Summary of Comments on P:\100\100.061\prelim plan\early grading\100.061early grading cover sheet C0.1 (1)

**PRELIMINARY DRAINAGE PLAN
PUD/SP 20-003**

THE HILLS AT LORSON RANCH

**STORMWATER MANAGEMENT PLAN
FOR THE HILLS AT LORSON RANCH**

**POND C2.2 AND POND C2.3
 POND GRADING AND
 TRICKLE CHANNEL**

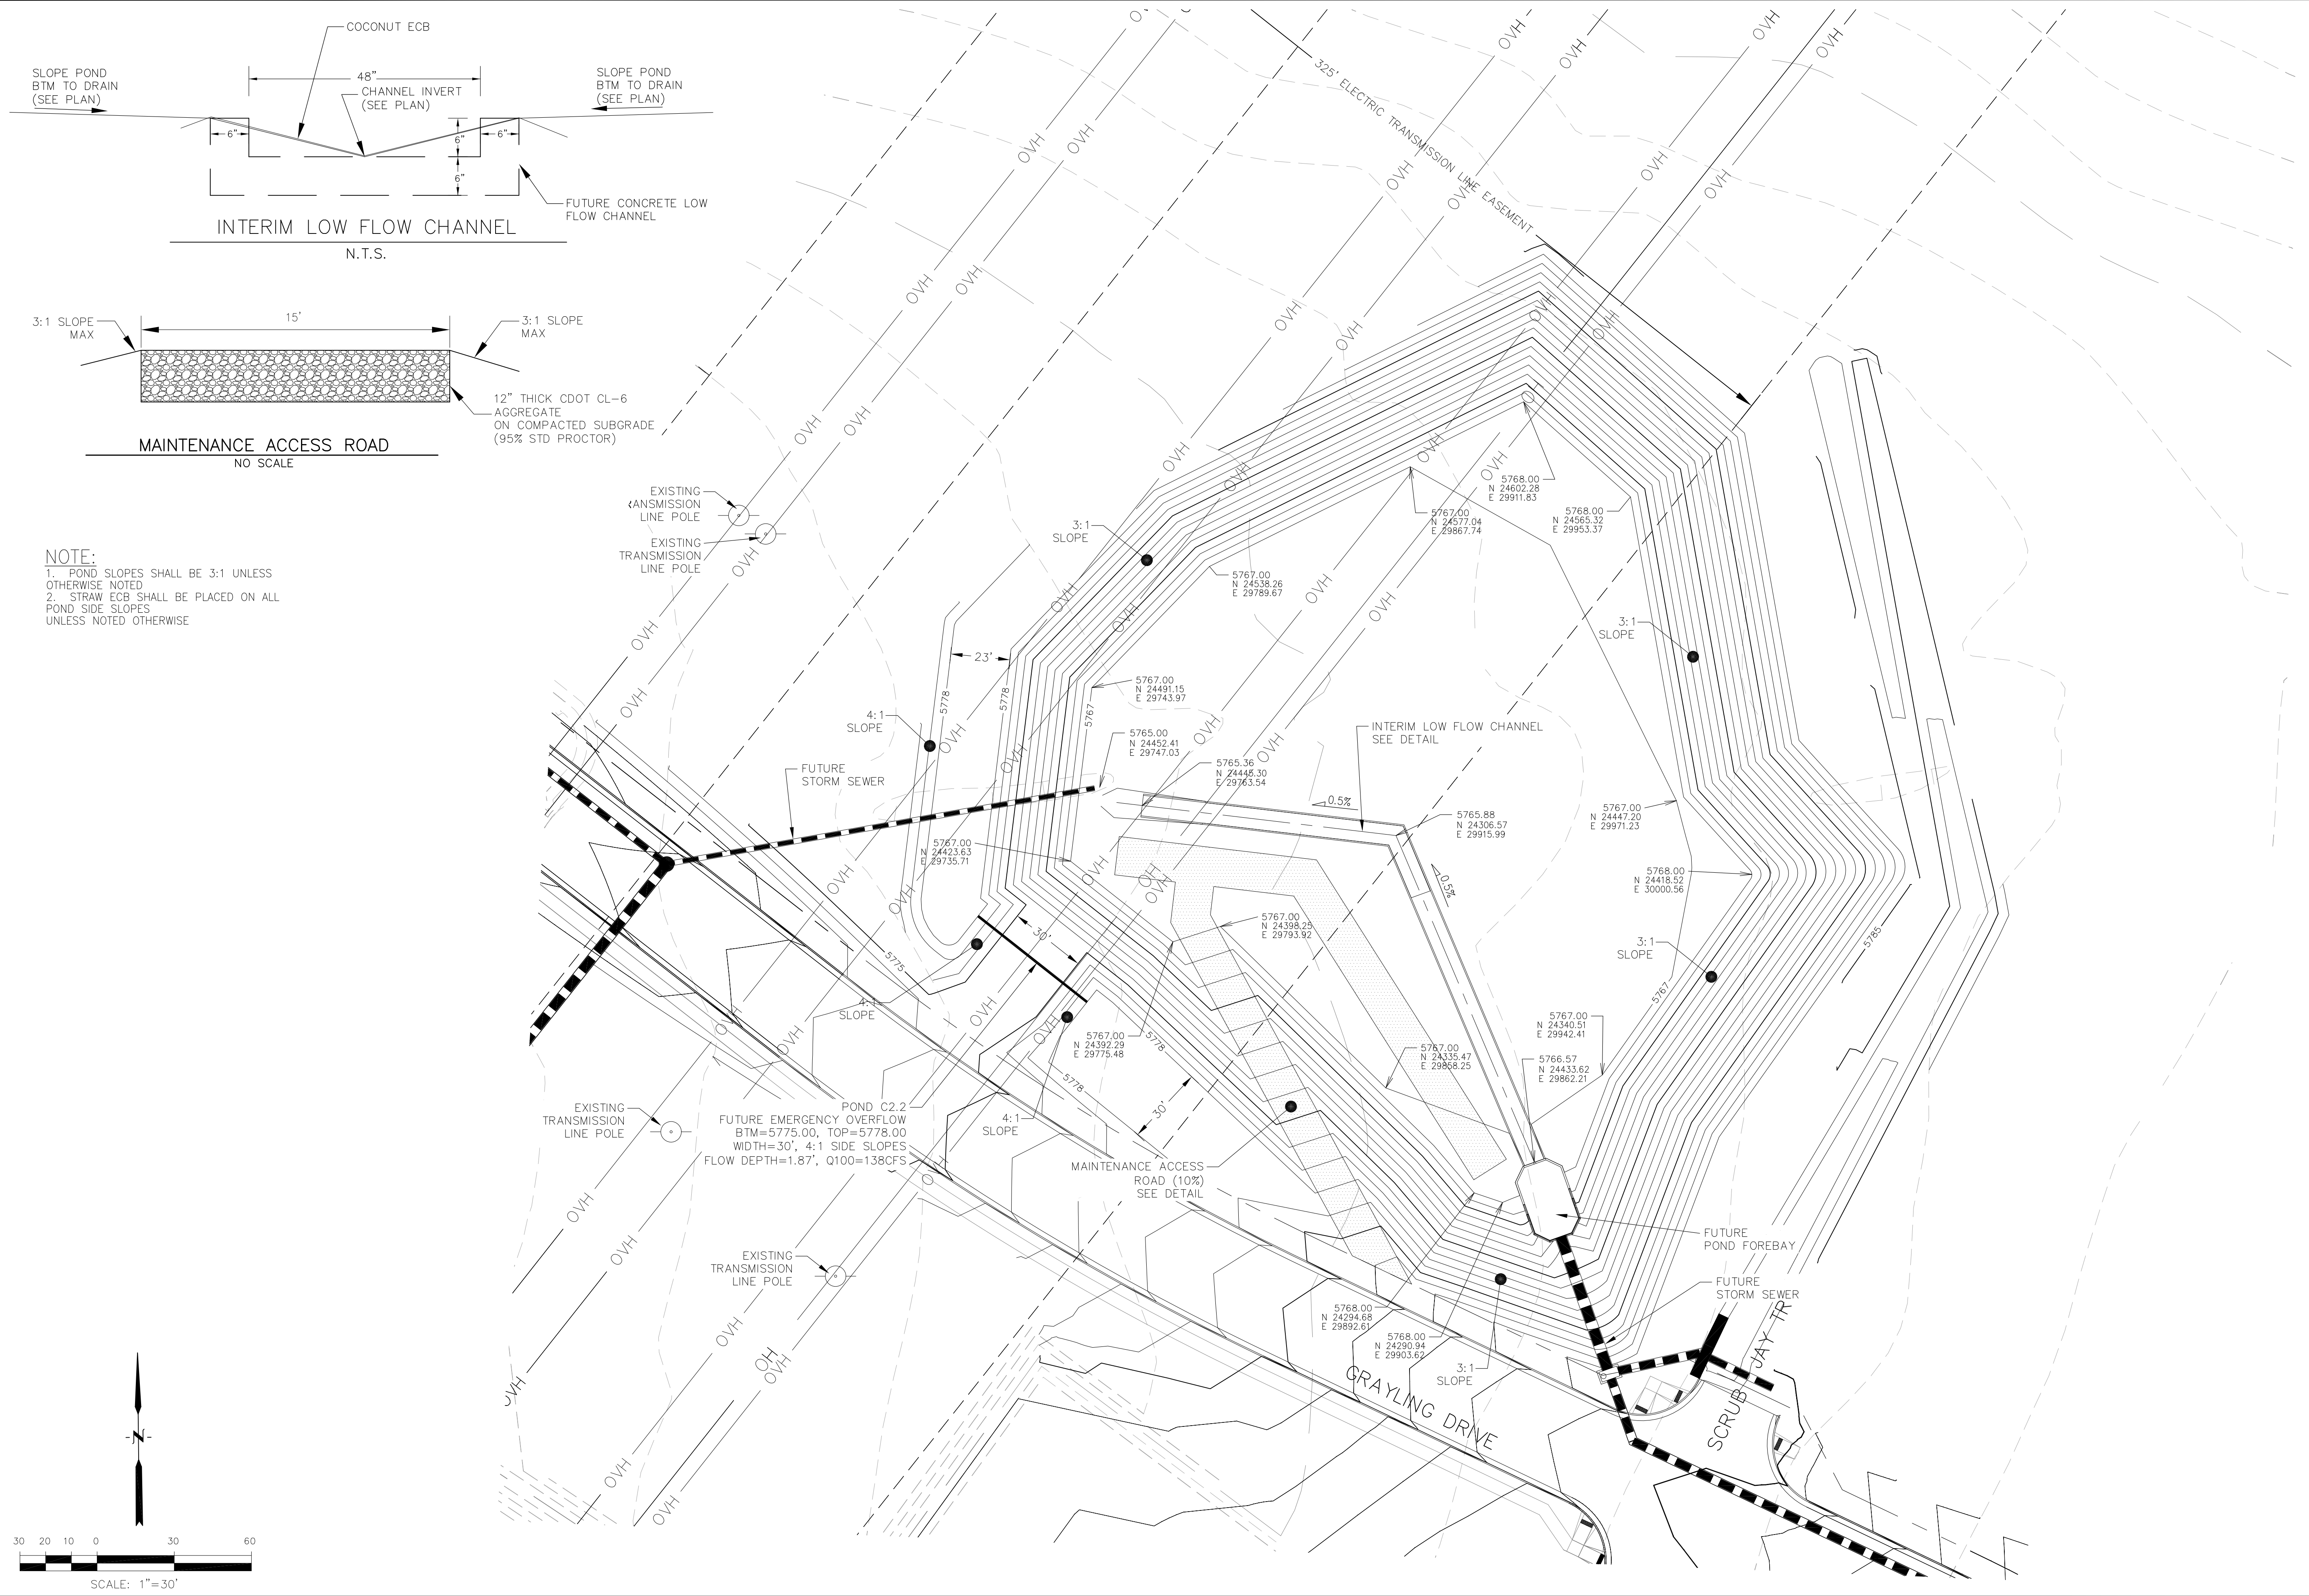
- Author: RSchindler Subject: Sticky Note Date: 10/21/2020 12:54:51 PM
ADDED NRE
- Author: dotrese Subject: Cloud+ Date: 8/11/2020 11:51:32 AM
point callout leader arrow at Pond C2.2. Note that the elevation differs from this sheet's callout to the one on Sheet C4.3

TEMPORARY SEDIMENT BASIN
TOP=5784.50
BTM = 5782.10
8" RISER PIPE
2 ROWS, 3 COLUMNS
1/2" HOLES
8" RISER PIPE AND
25' TYPE R INLET

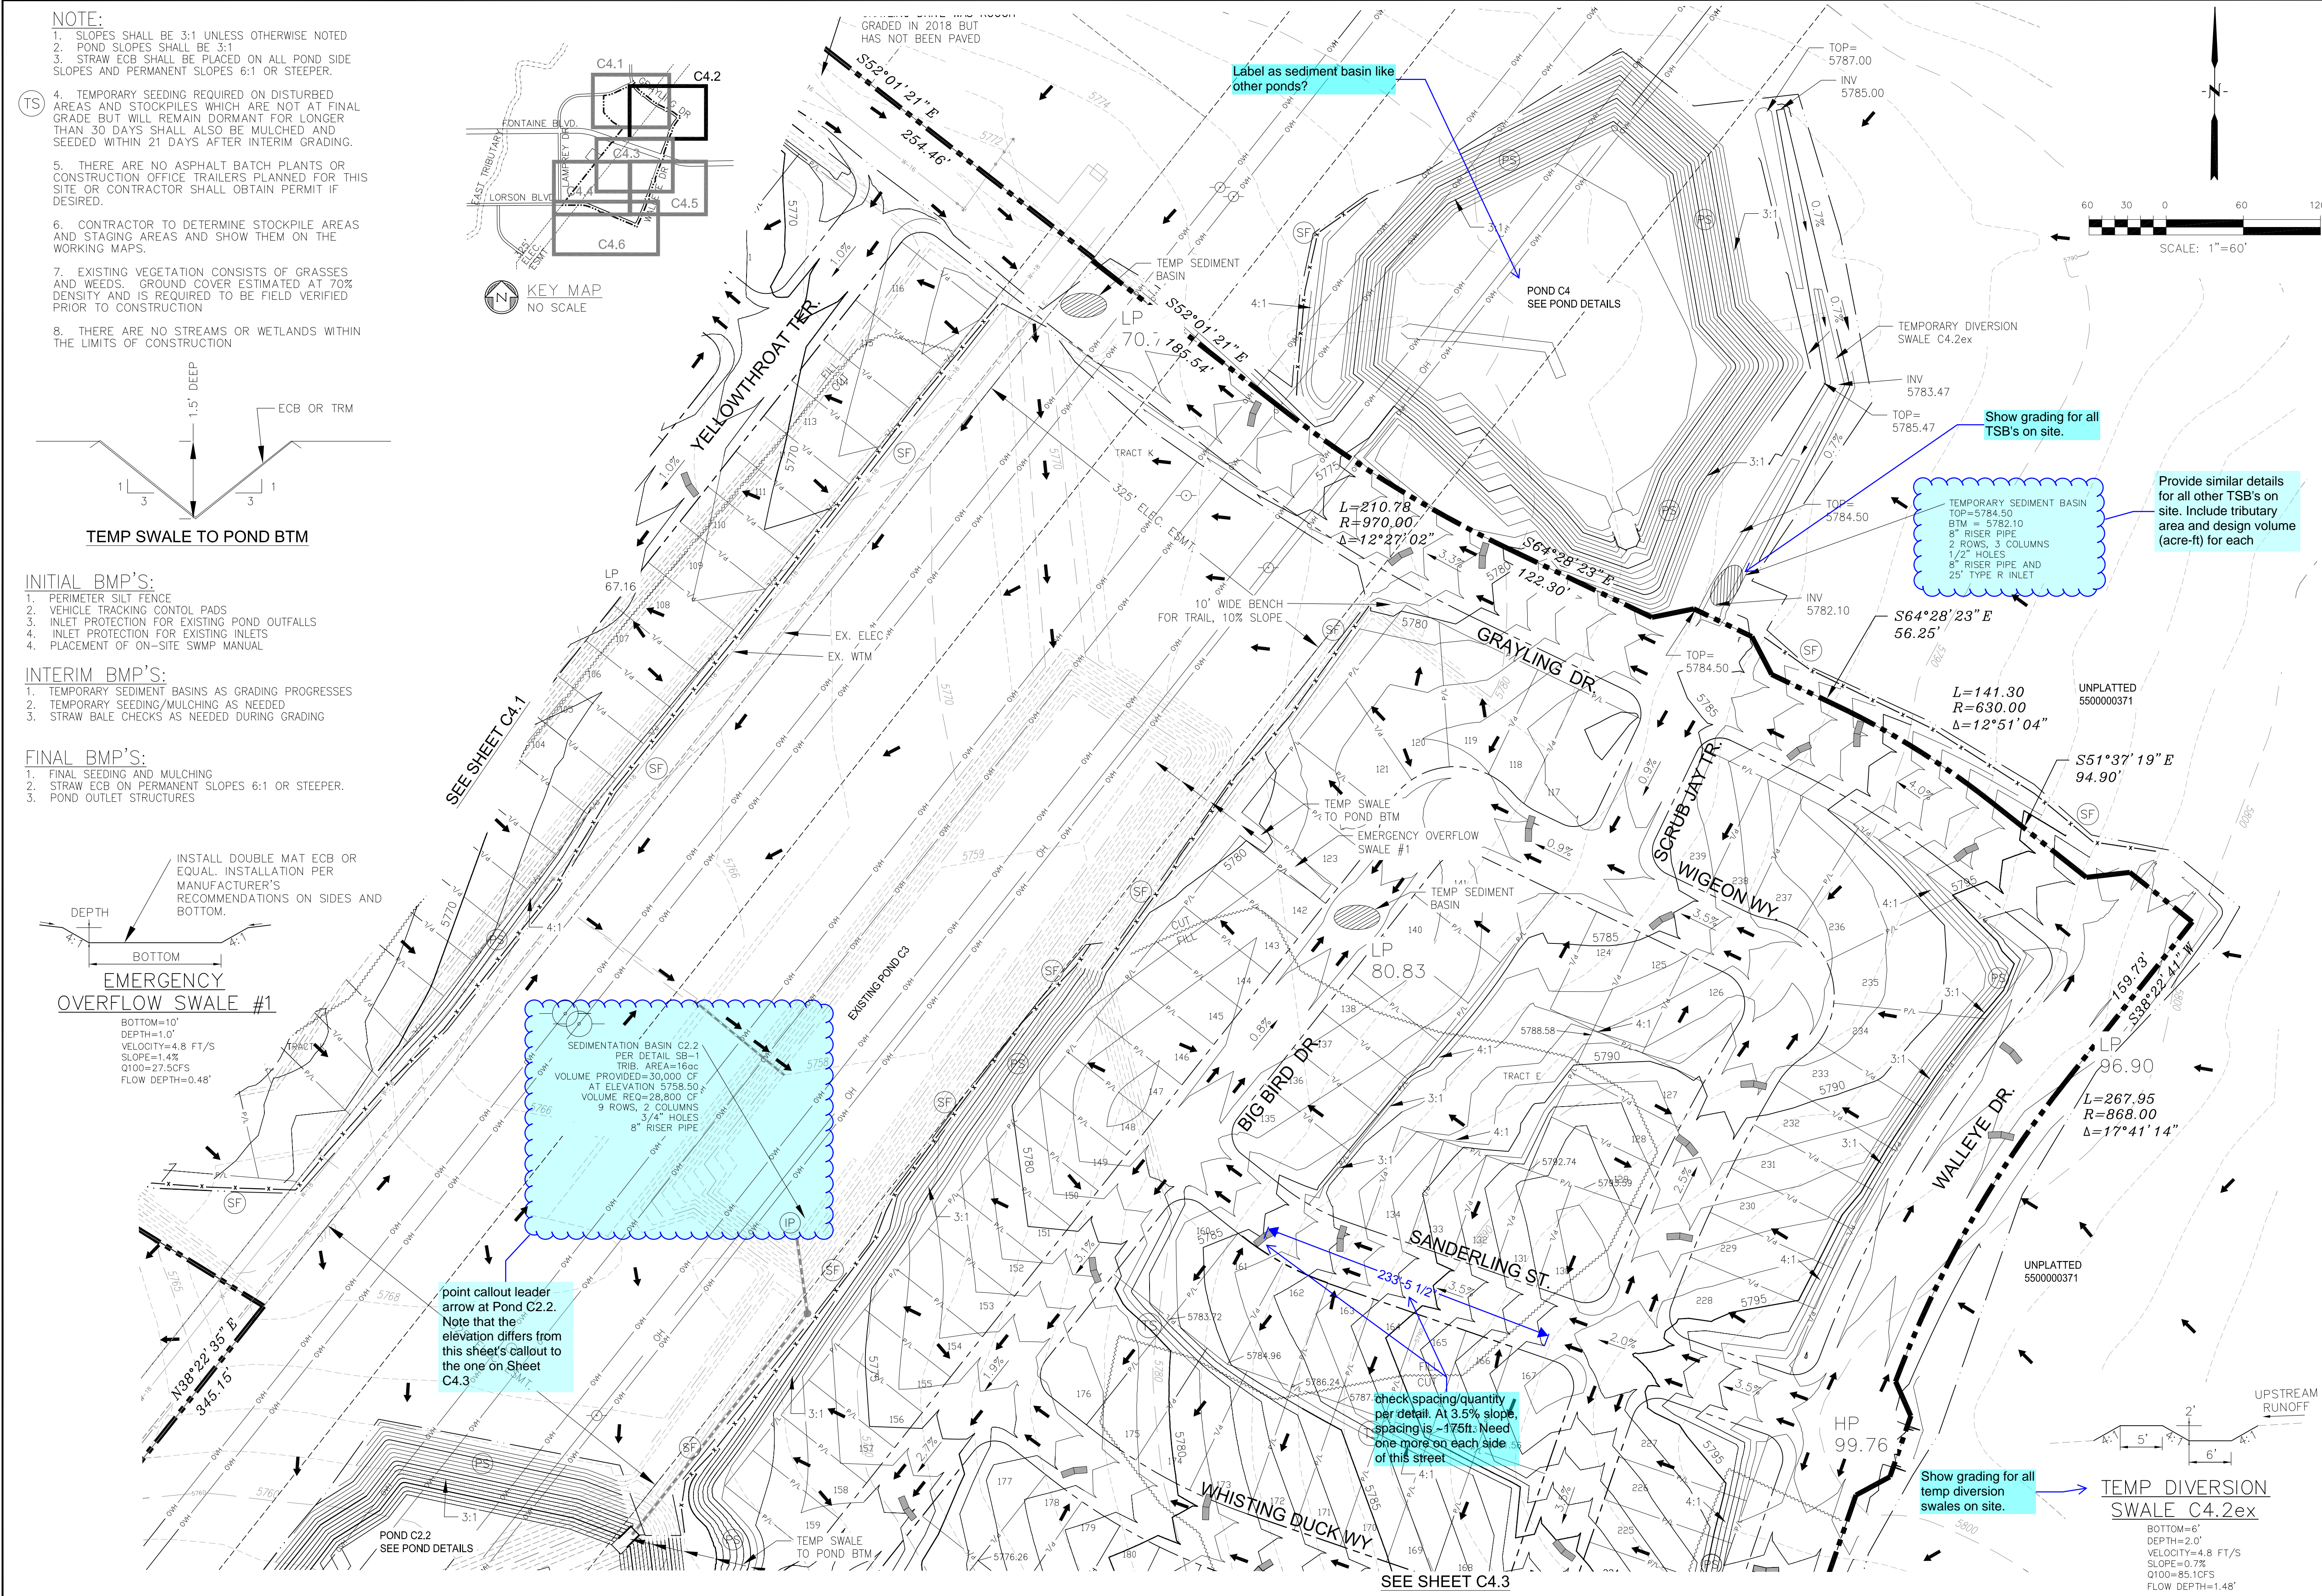
- Author: dotrese Subject: Cloud+ Date: 8/11/2020 2:49:28 PM
Provide similar details for all other TSB's on site. Include tributary area and design volume (acre-ft) for each

- Author: RSchindler Subject: Sticky Note Date: 10/21/2020 1:03:17 PM
CHANGED TO SED. TRAPS
- Author: dotrese Subject: Dimension Date: 8/11/2020 1:47:37 PM
233'-5 1/2"
